COUNTY COUNCIL'S RESPONSE TO CONSULTATION ON THE FOLLOWING DEVELOPMENT PROPOSAL

Application No: 18/00825/HYBRID-4

Proposal: Demolition of buildings and structures as listed in Schedule 1; Outline planning permission for up to 1,175 new dwellings (Class C3); 60 close care dwellings (Class C2/C3); 929 m2 of retail (Class A1); 670 m2 comprising a new medical centre (Class D1); 35,175 m2 of new employment buildings, (comprising up to 6,330 m2 Class B1a, 13,635 m2 B1b/c, 9,250 m2 Class B2, and 5,960 m2 B8); 2.4 ha site for a new school (Class D1); 925 m2 of community use buildings (Class D2); and 515 m2 of indoor sports, if provided on-site (Class D2); 30m in height observation tower with zip-wire with ancillary visitor facilities of up to 100 m2 (Class D1/A1/A3); 1,000 m2 energy facility/infrastructure with a stack height of up to 24m (sui generis); 2,520 m2 additional education facilities (buildings and associated external infrastructure) at Buildings 73, 74 and 583 for education use (Class D1); creation of areas of Open Space, Sports Facilities, Public Park and other green infrastructure; Change of Use of the following buildings and areas: Buildings 357 and 370 for office use (Clas

FIG 6 COMPOSITE PARAMETER PLAN

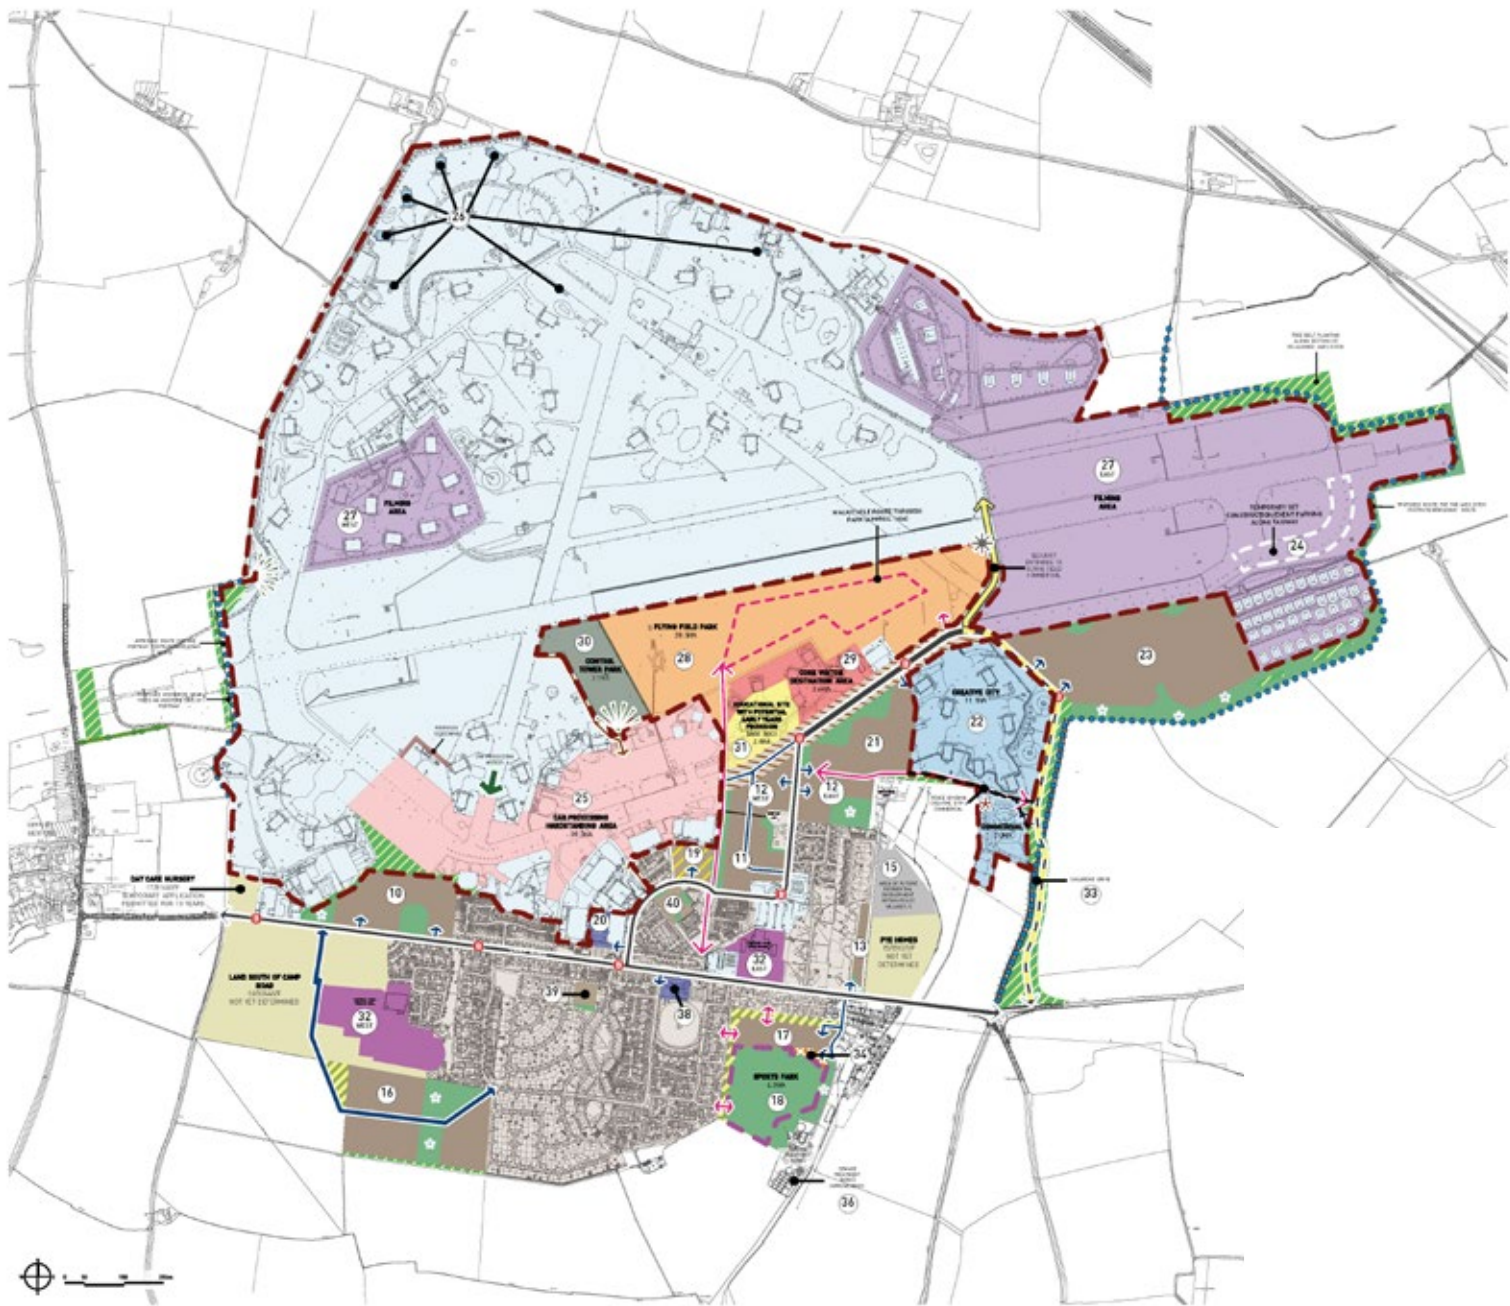
- The composite parameter plan incorrectly shows the route of the Aves Ditch reinstatement.

- 2) Composite Parameter Plan: P16-0631_08AK. This plan still appears shows the route of Aves Ditch (blue dots) passing outside of the current southern bomb store fencing on south and south-eastern edges, rather than inside the fencing between the fence and the bunds. This contrasts with the eastern and northern edges where the route is shown inside the boundary. Whilst the plan's depiction of the route to the south of the southern bomb store remains unclear this element of the application is **objected to**. The width of the section crossing of

Flying Fields also needs clarifying to ensure it meets at least minimum width obligations in current condition. The proposed tree belt plantation at north east corner must be planned and delivered so that the planting process and the maturing trees' canopy do not take up any of the full width of the bridleway and that the trees to not create a maintenance or safety liability.
